From: Simon Davis
Sent: 04 July 2018 14:31
To: Planning.Responses
Subject: FW: 97 Barnham Road, Eastergate - EG/107/17/DOC

Martin J. Harvey B.Sc., C.Eng., MICE
Consultant Civil Engineer

97 Barnham Road, Eastergate - EG/107/17/DOC

Number
S17-03-01 E

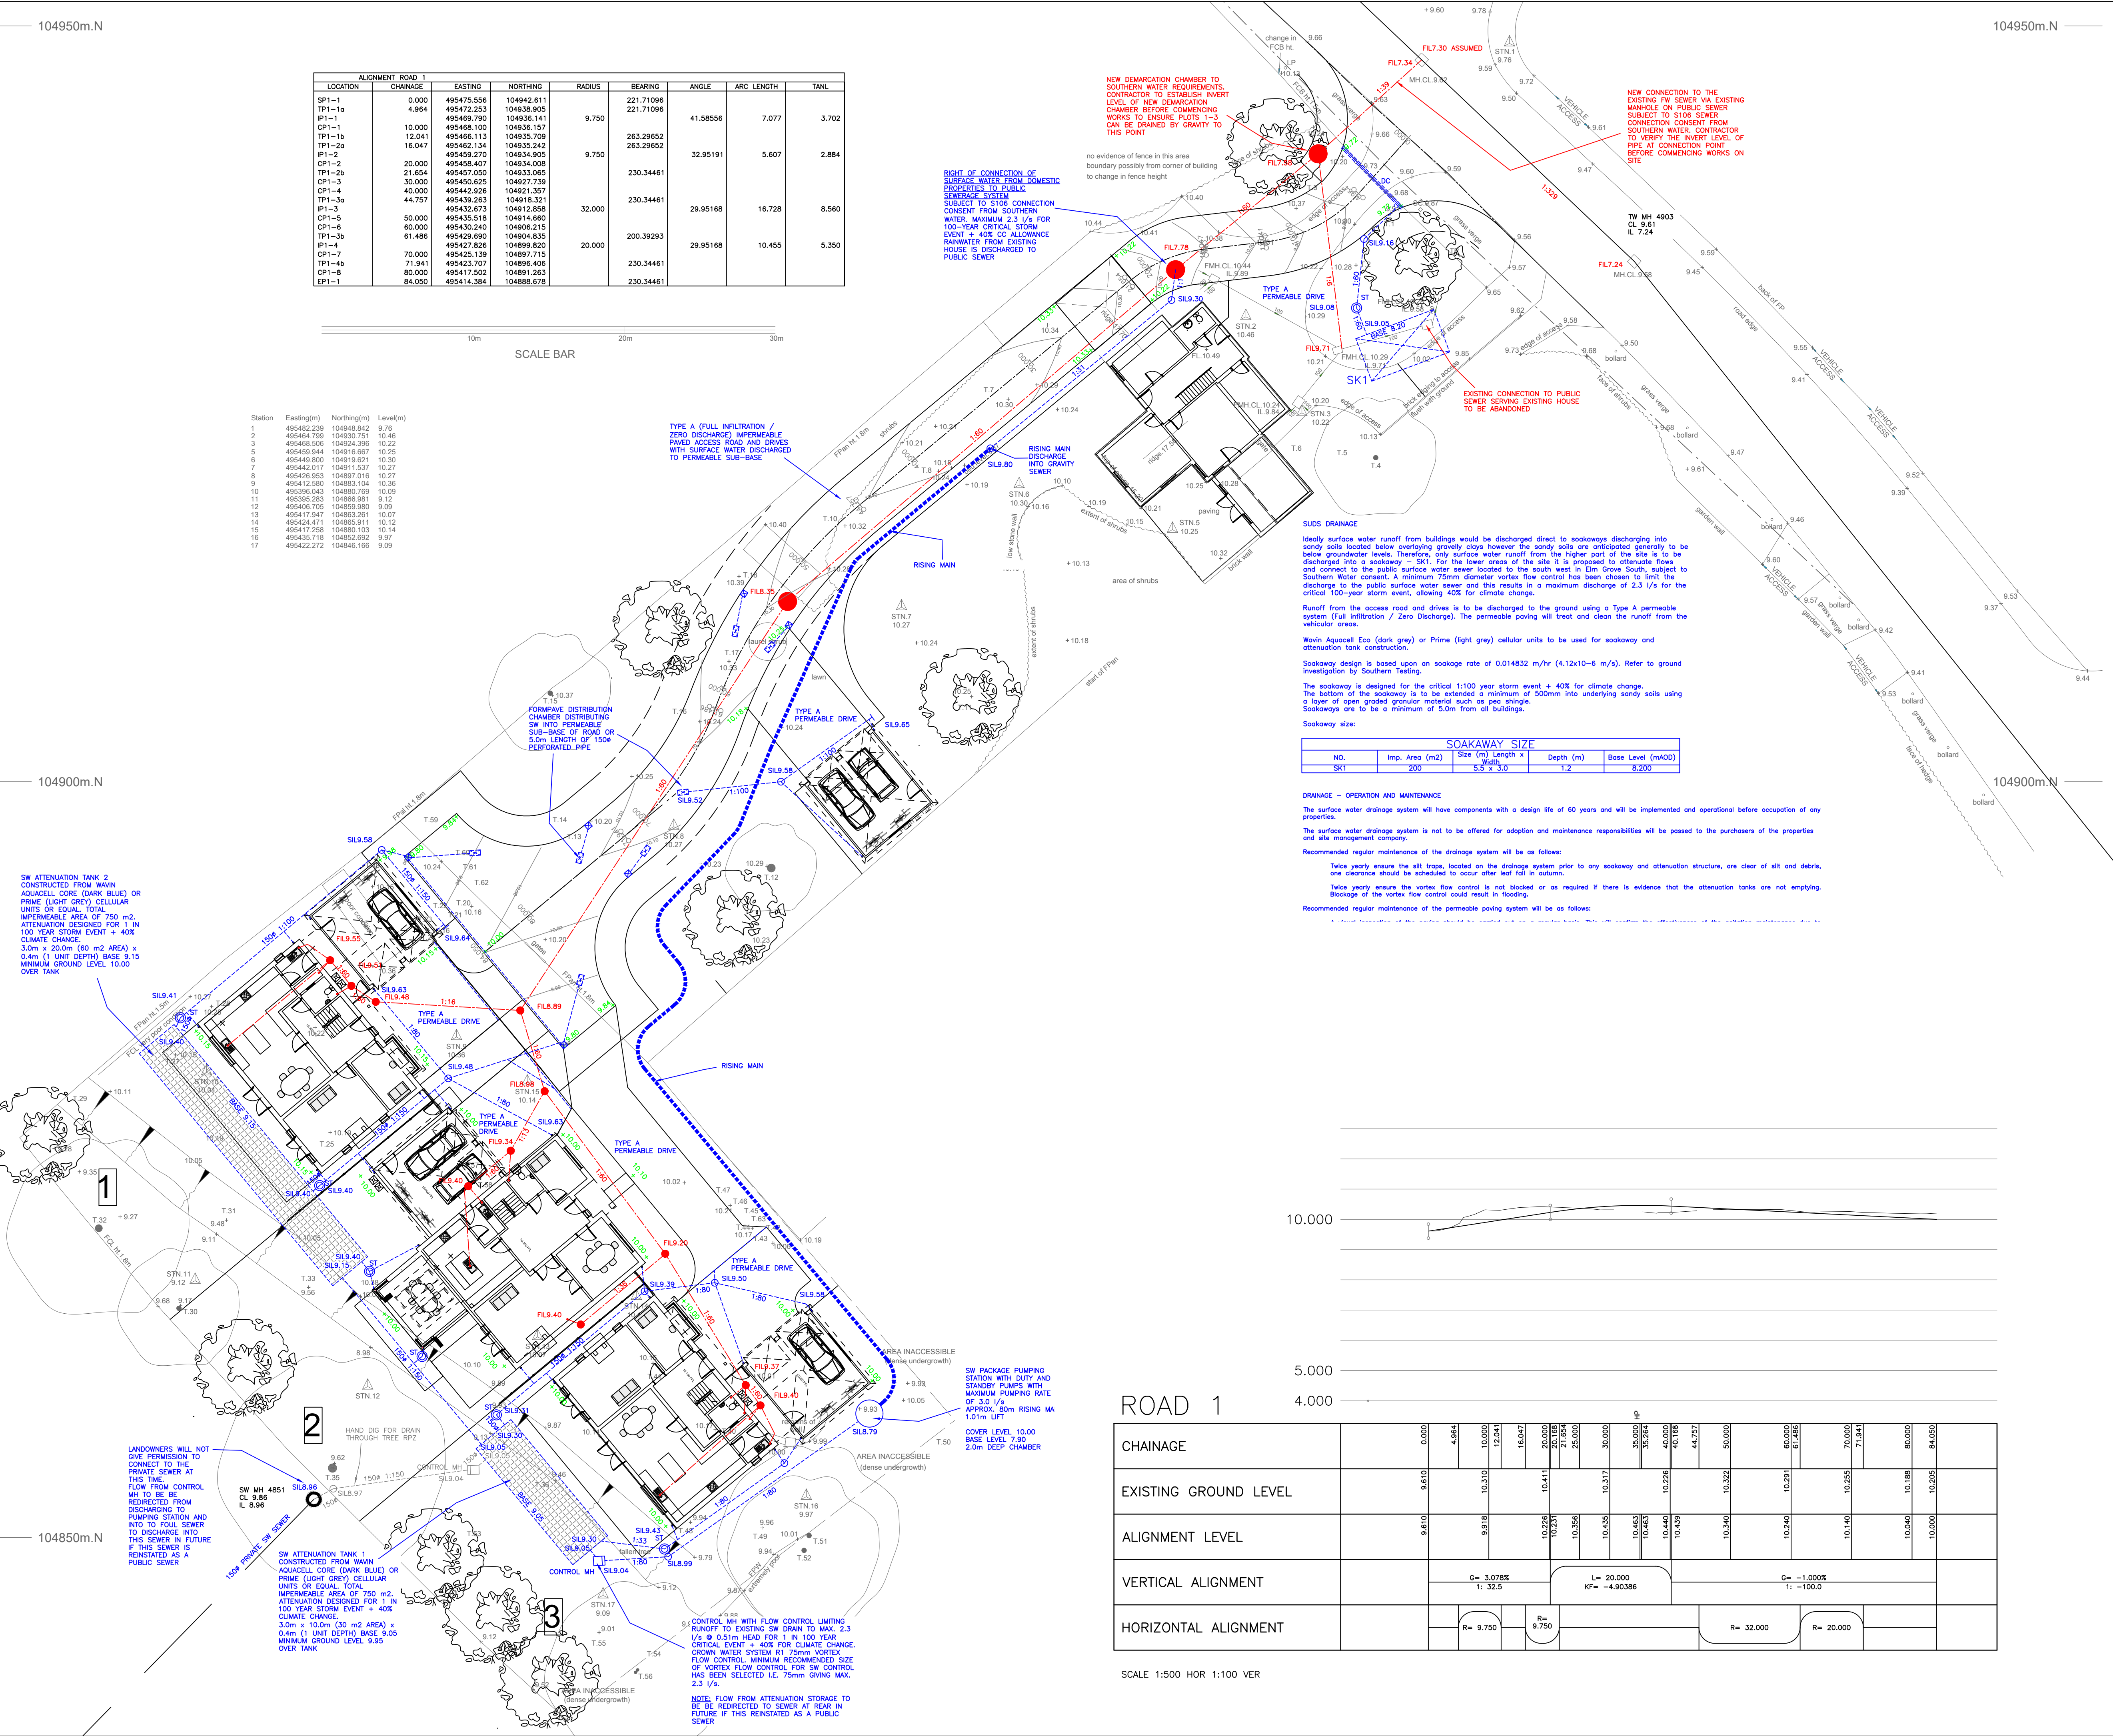
"However, we need to see an additional manhole and length of gravity pipe (to be laid at an agreed gradient) at the downstream extent of the rising main. Not including this could result in serious problems with backing up of foul water and blockages occurring as a result."

Regarding the request for an additional length of gravity at the end of the rising main I fail to understand why this is necessary. There is an intermittent surface water discharge, during rainfall events, of a maximum of 3.0 l/s entering into the manhole on a side branch which will be directed down the sewer. This will be clean water as the rainwater will have passed through silt traps, attenuation tanks and flow control before reaching the pumping station. The foul flow in the manhole is from 3 dwellings giving a 'Sewers for Adoption' flow of 0.138 l/s. The maximum flow of (3.0 + 0.138) 3.138 l/s is less than 50% of the capacity of the 100mm sewer @ 6.8 l/s. How will the direct connection of the rising main result in serious problems of backing up of foul water? A gravity connection of surface water into the manhole will result in the same flow rates. I accept the gravity drain may attenuate the pumped flow a small amount but I do not see how that is necessary in this case.

Ultimately, this is a private drainage system to be maintained by a management company who will have responsibility to deal with blockages and any defects. Building Control have approved the drainage system as installed.
